TO: Jean Fraser, Planner  
FROM: David Senus, P.E.  
DATE: August 27, 2013  
RE: 133 York Street – 6 Unit Residential Building, Level III Site Plan

*first review comments*

**TO:** Jean Fraser, Planner  
**FROM:** David Senus, P.E.  
**DATE:** September 6, 2013  
**RE:** 133 York Street – 6 Unit Residential Building, Level III Site Plan; Response to Comments

C1.1

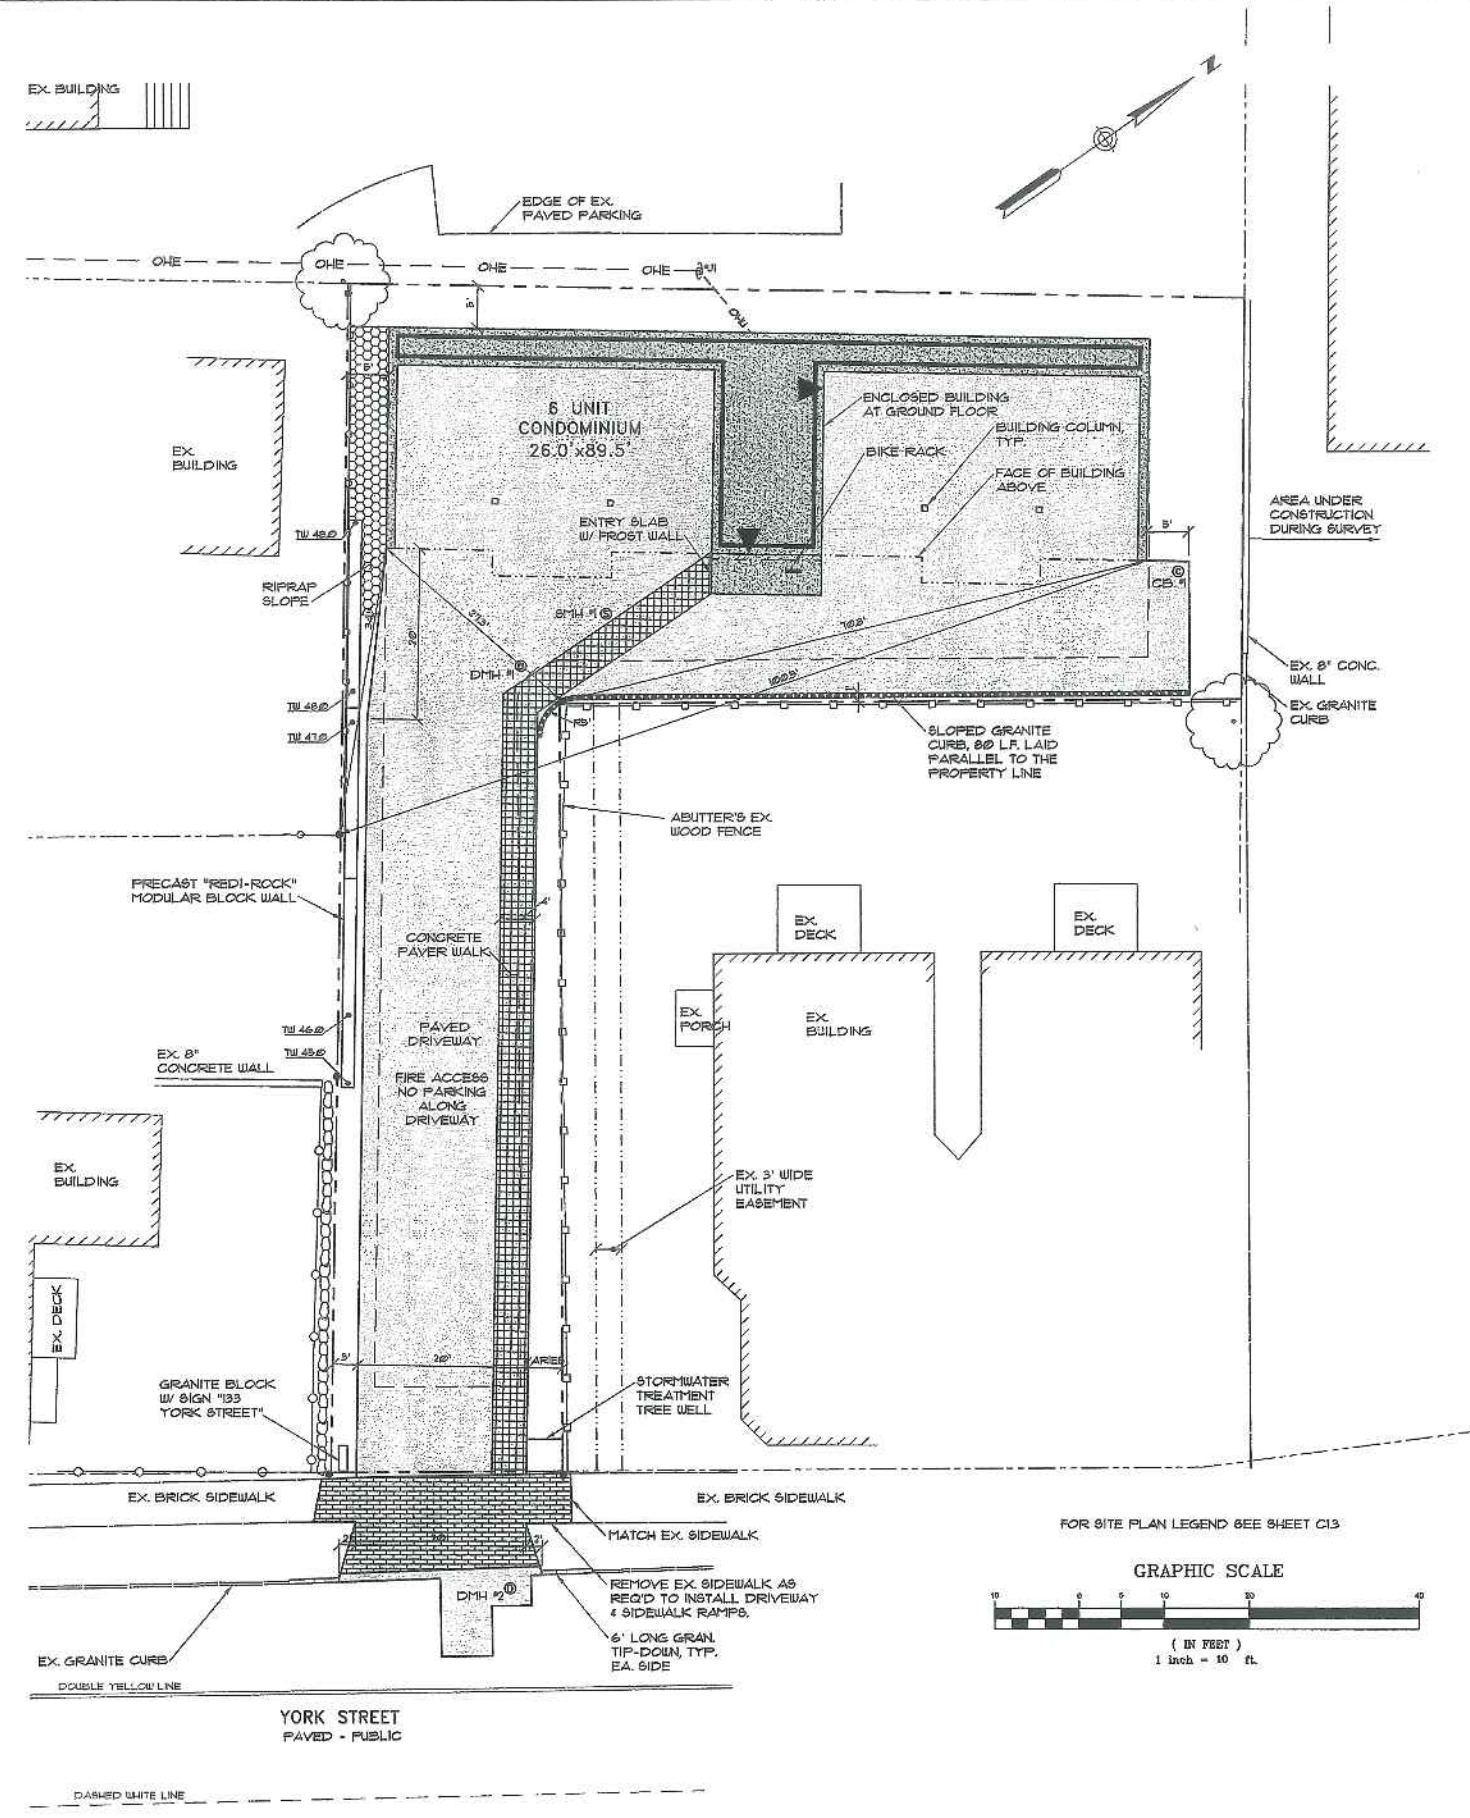
- 6) Note 3 on C1.1 states that "All Powerline Utilities Shall Be Overhead"; however, a note on C1.3 indicates an underground connection from the utility pole at the rear of the building; please clarify. In addition, it appears that an easement will be required from McCormick Place Condominium for this underground utility connection.

- 4) Comment adequately addressed.
- 5) Comment adequately addressed.
- 6) Power and telecommunications connections to the building are required to be underground; we anticipated that an easement will be required from McCormick Place Condominium for this underground utility connection.

C1.3

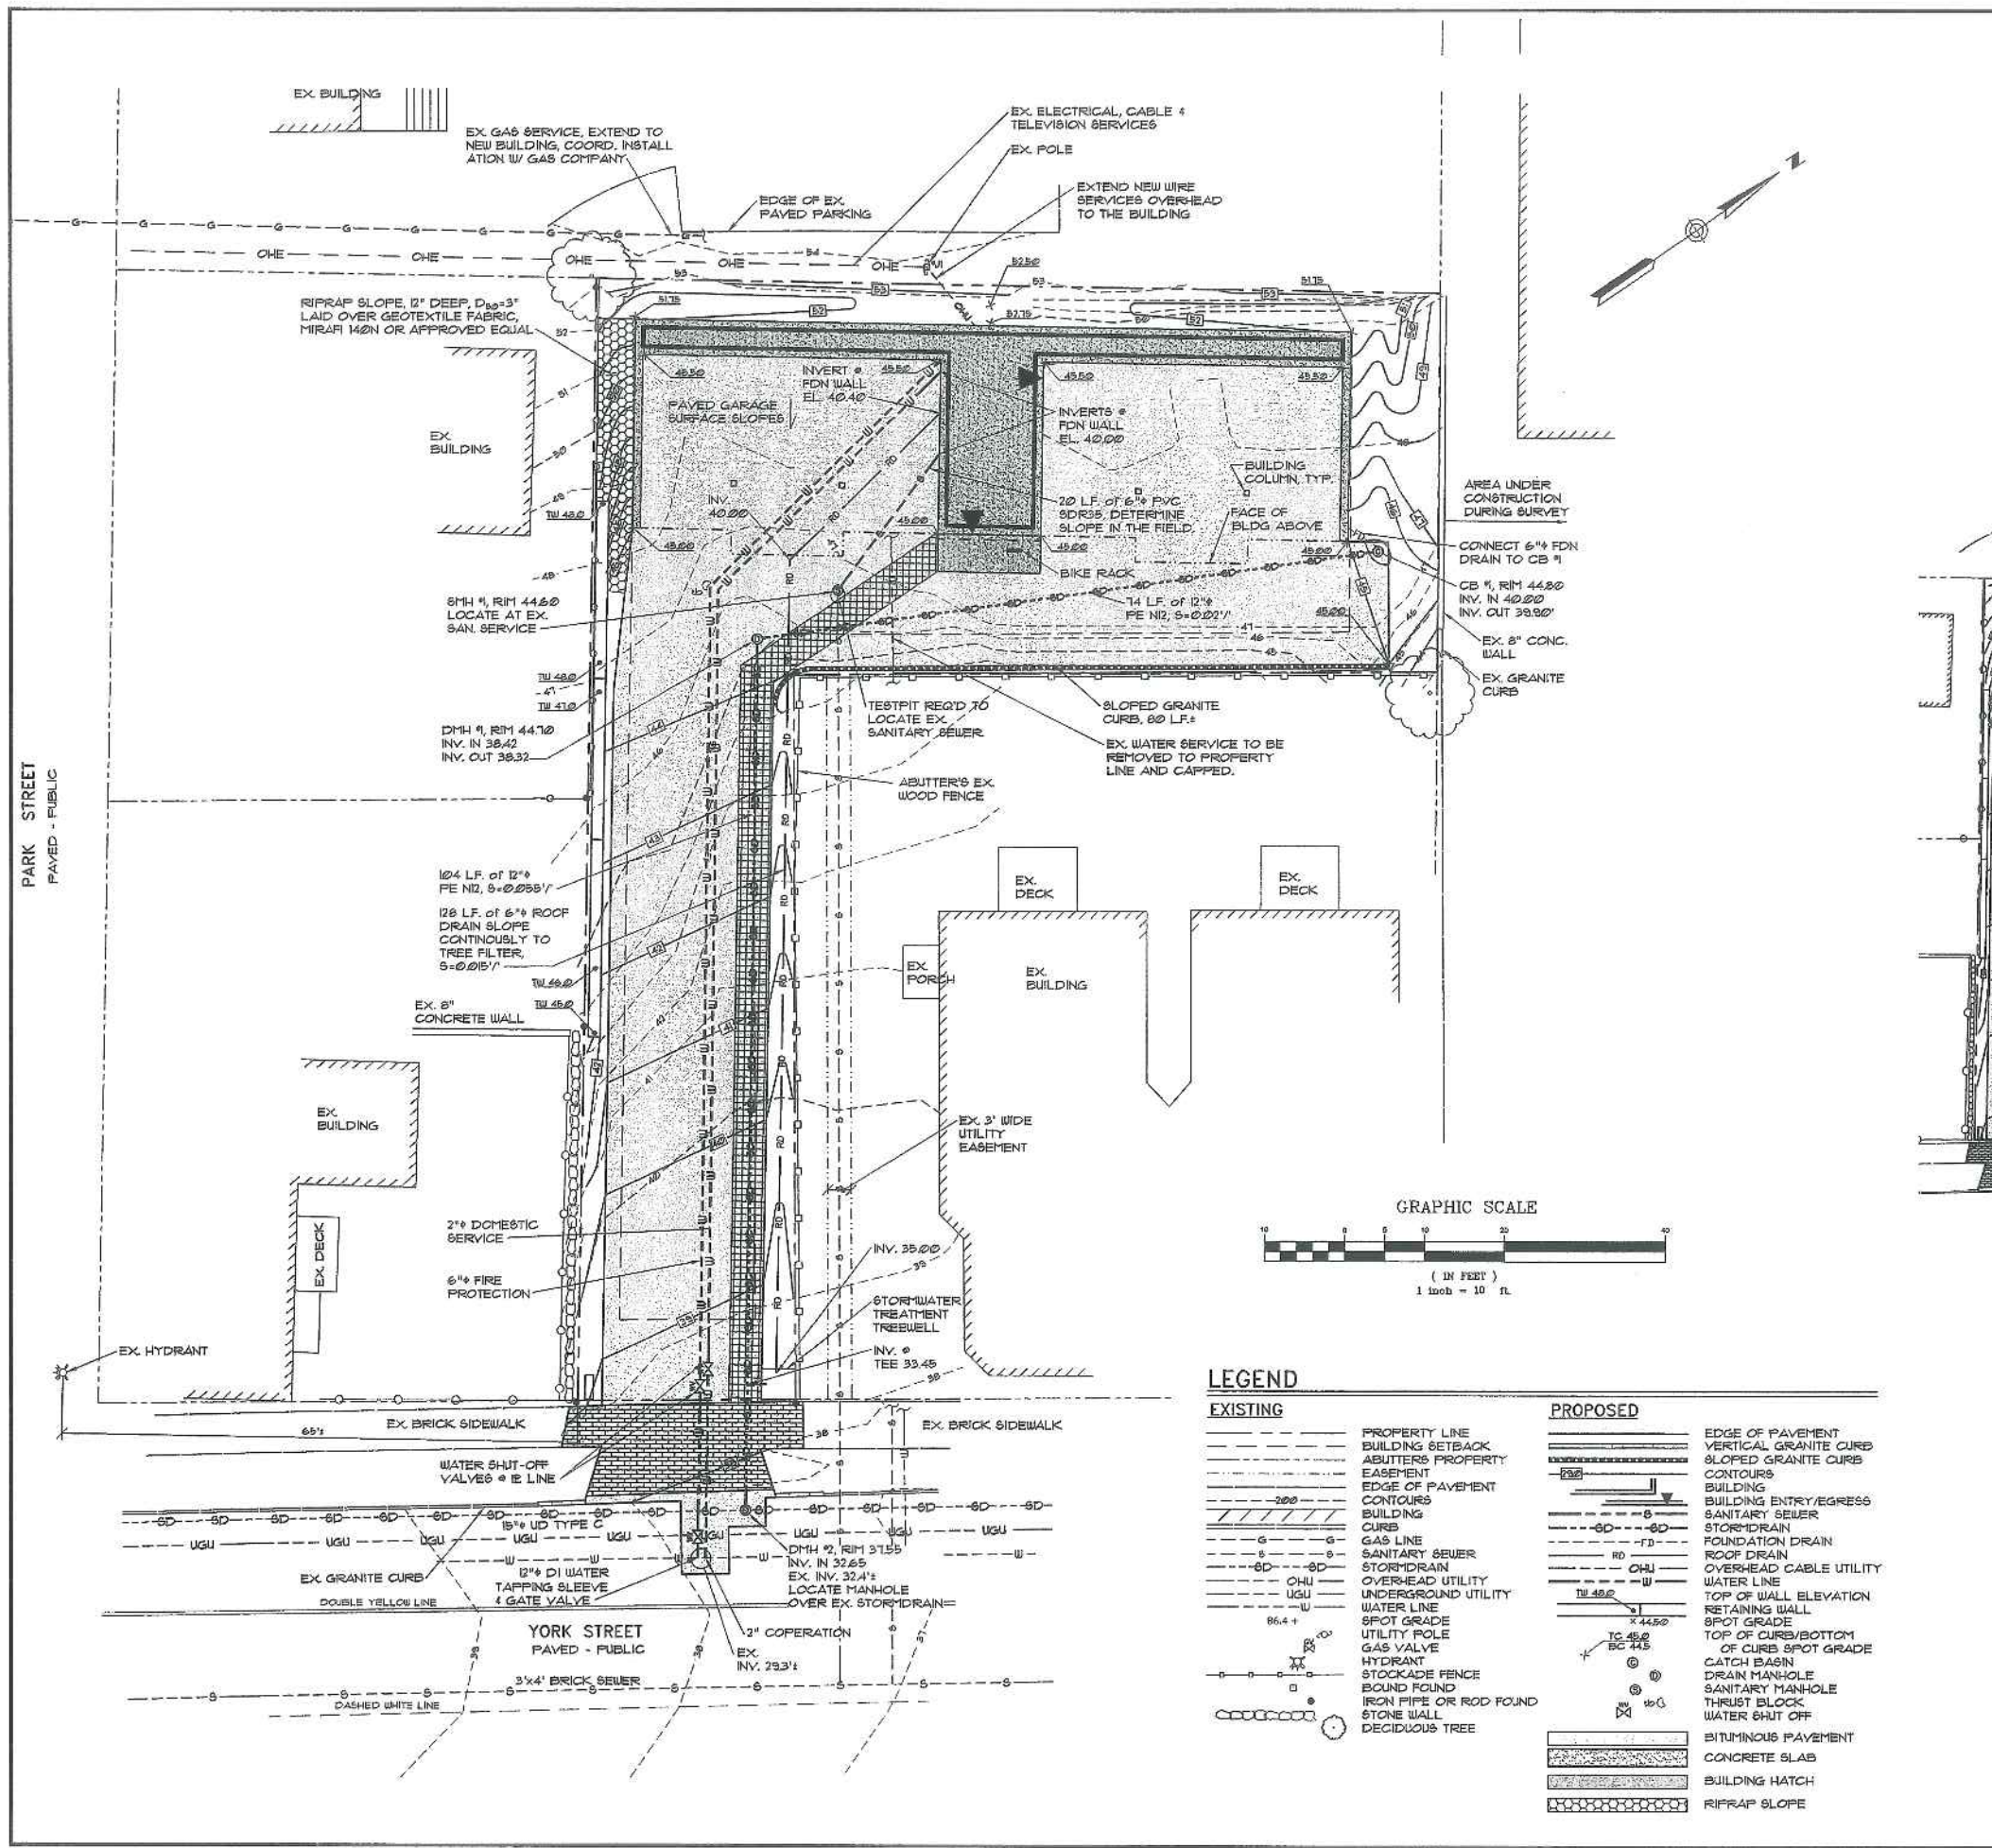
- 5) Proposed topography on C1.3 indicates that a portion of the drainage from uphill lots will be routed directly along the west building wall, please review the grading in this area.

VERSION 1.00
 JUNE 26, 2009
 SCALE: AS NOTED
 GENERAL DESIGN
 DETAILS & SPECIFICATIONS
 C2.4

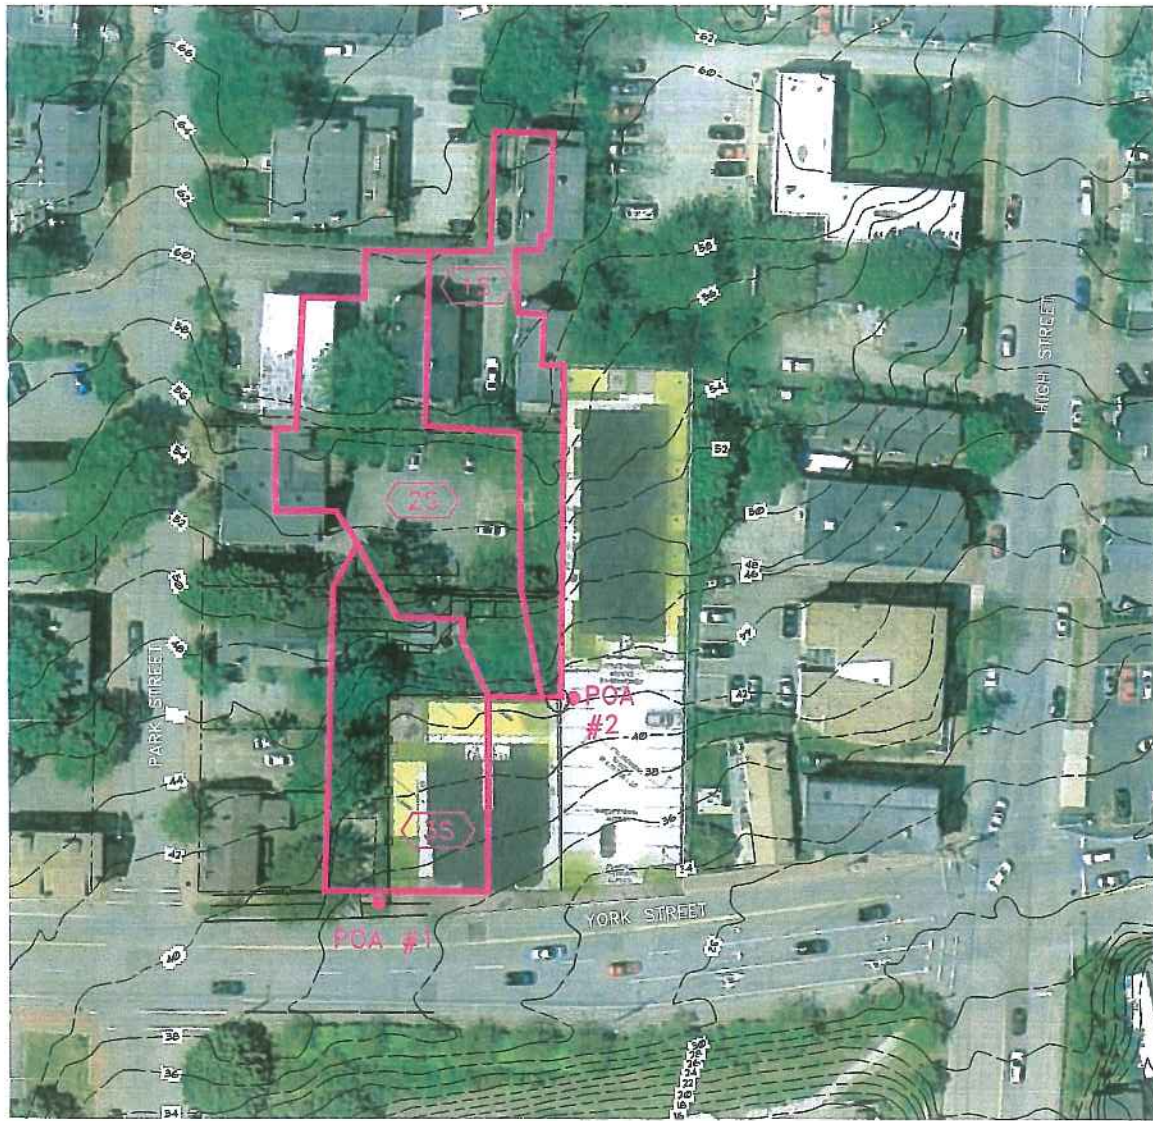
- b) General Standard: The Applicant has proposed a stormwater tree well to treat runoff from an impervious area in excess of the proposed new impervious area; the approach meets the intent of the General Standards. The Applicant should provide calculations on the sizing and design of the tree filter system, and clarify the system dimensions on Tree Filter detail sheet.

- 4) Provide additional information related to the roof drain connection to the treewell filter and the treewell filter connection to the site's storm drain system (provide pipe sizes, invert elevations, and detail the connections to the tree filter).

- 1) Basic General and Flooding Standards:
  - a. Comment adequately addressed.
  - b. Please provide design calculations or verification from the manufacturer confirming that the 4x6 tree filter unit, as proposed, is sized and designed to accommodate the water quality storm event for the contributing land area.
